Rezoning Transportation Analysis

Petition Number: #2022-024

3Revision Log:

Date	Description
07-26-22	First Review (TM)
08-24-22	Second Review (TM)

SHEET NUMBER  
**RZ-01**

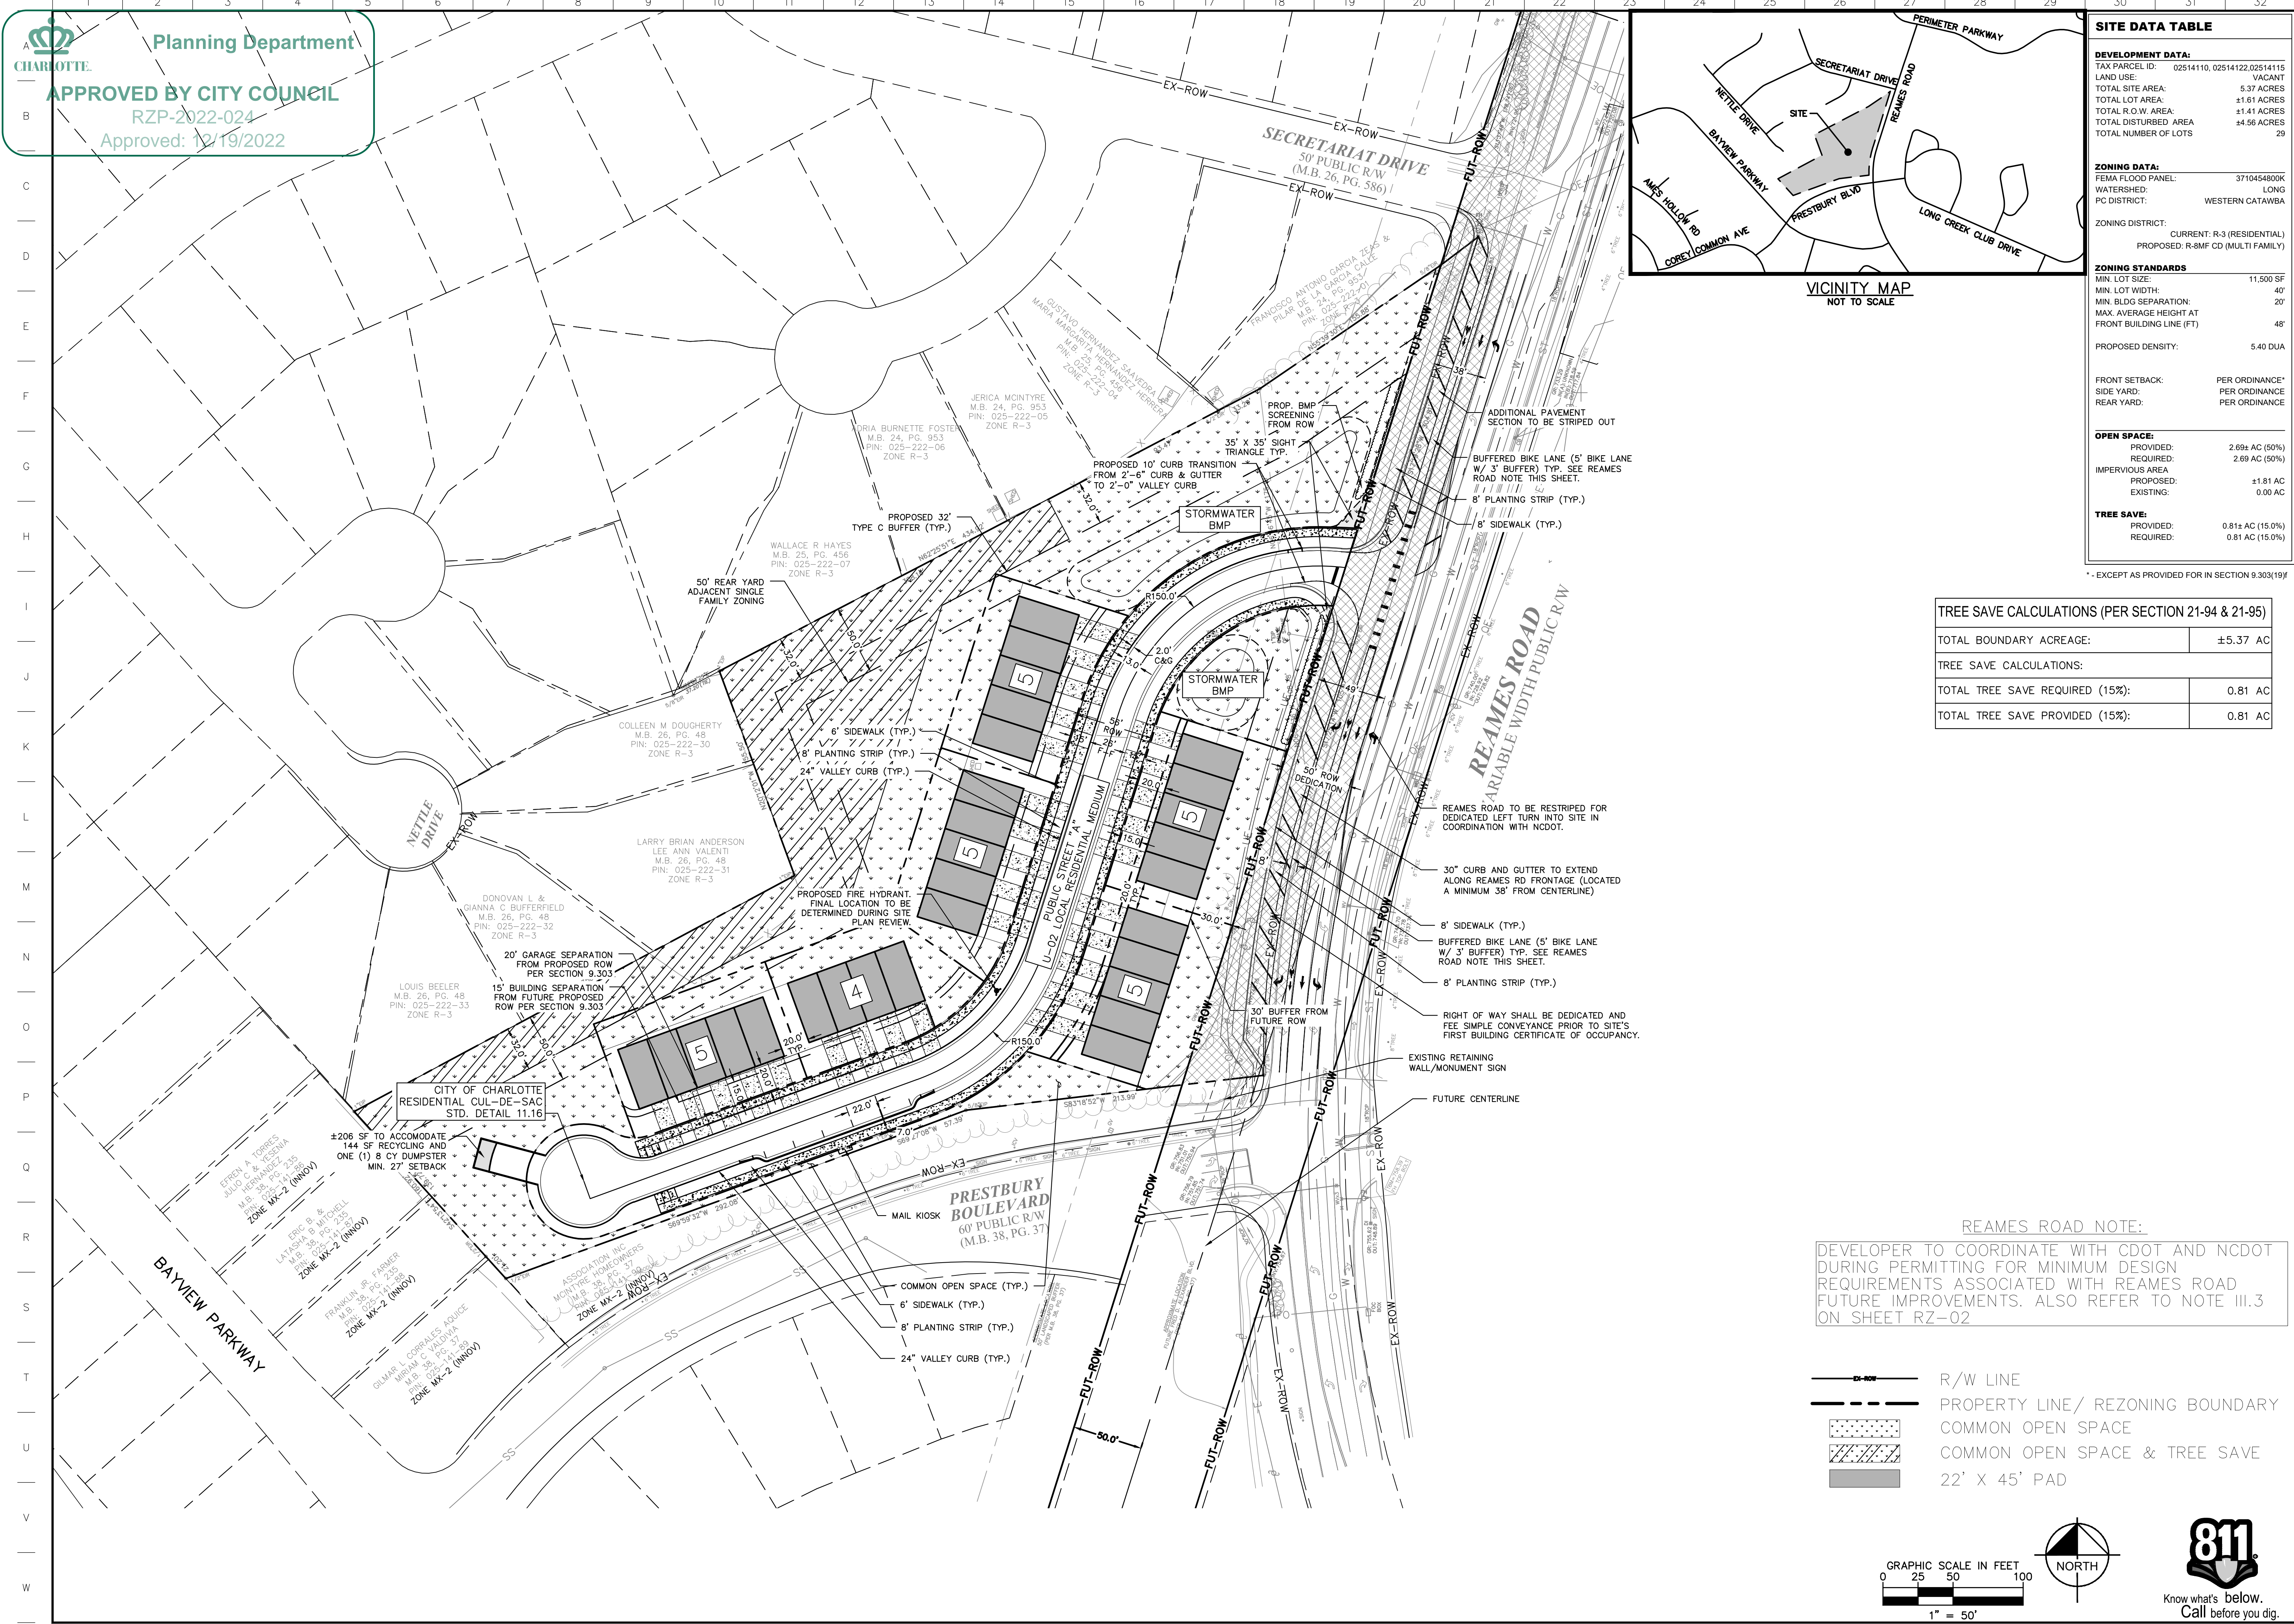
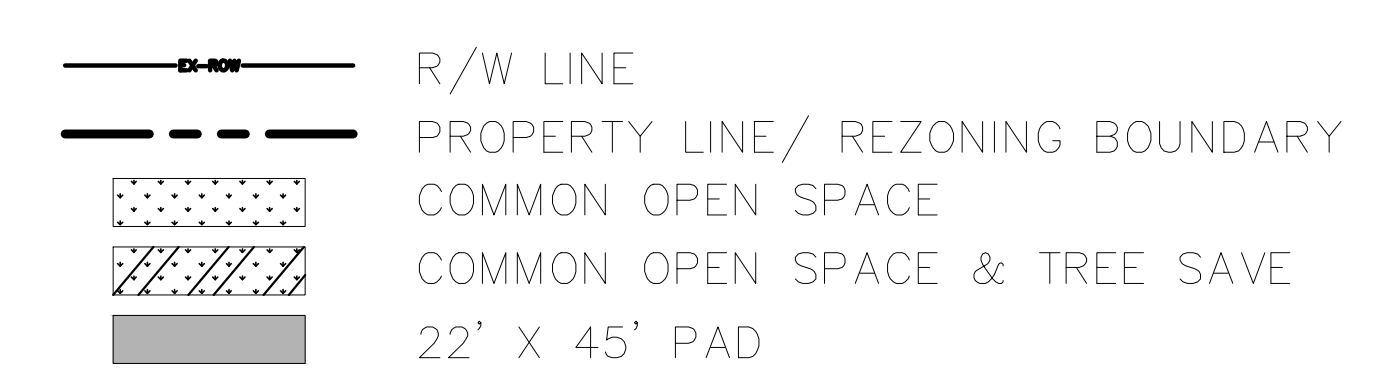
1. **Curbline:** The proposed zoning district has a setback measured from back of the existing or proposed future curbline.
 - a. **Reames Road:** The future location of curb and gutter is located 38-feet from the centerline.

Outstanding Comment from 07-26-22: Label and dimension the curb and gutter from the centerline for each road on the site plan.
2. ~~**Traffic Study:**~~
~~A Traffic Impact Study (TIS) is not necessary for the complete review of this petition due to the site generating less than 2,500 daily trips. If during the permitting process the site generates more than 2,500 daily trips, then a traffic study will be required.~~

3. **Outstanding Comment from 07-26-22:** Revise site plan and conditional note(s) to commit to dedicate 50-feet of right-of-way from the road centerline. The site plan shall label and dimension the right-of-way from the Reams Road centerline.

4. **Outstanding Comment from 07-26-22:** Site plan and conditional note(s) revisions are needed to commit to restriping Reames road for a left-turn lane into the site per NCDOT coordination. Label and dimension left-turn lane on site plan and add conditional note describing all turn lane design requirements.

5. **Outstanding Comment from 07-26-22:** Site plan revisions are needed to dimension to location of the future right-of-way to be dedicated for the proposed CTP alignment.

6. **CDOT REQUEST:** CDOT requests the internal street be constructed as a private street built to public street standards.
7. **Outstanding Comment from 07-26-22:** Site plan and conditional note(s) revisions are needed to commit to construct bicycle facilities by locating the curb and gutter 38' from the center line to meet the Charlotte BIKES Council-Adopted Policy. The right turn lane for Prestbury Road is not accounted for in the 38-foot measurement, so additional space will be required for the existing right turn lane. Provide buffered bike lane along the frontage of the site between the through and right turn lane.
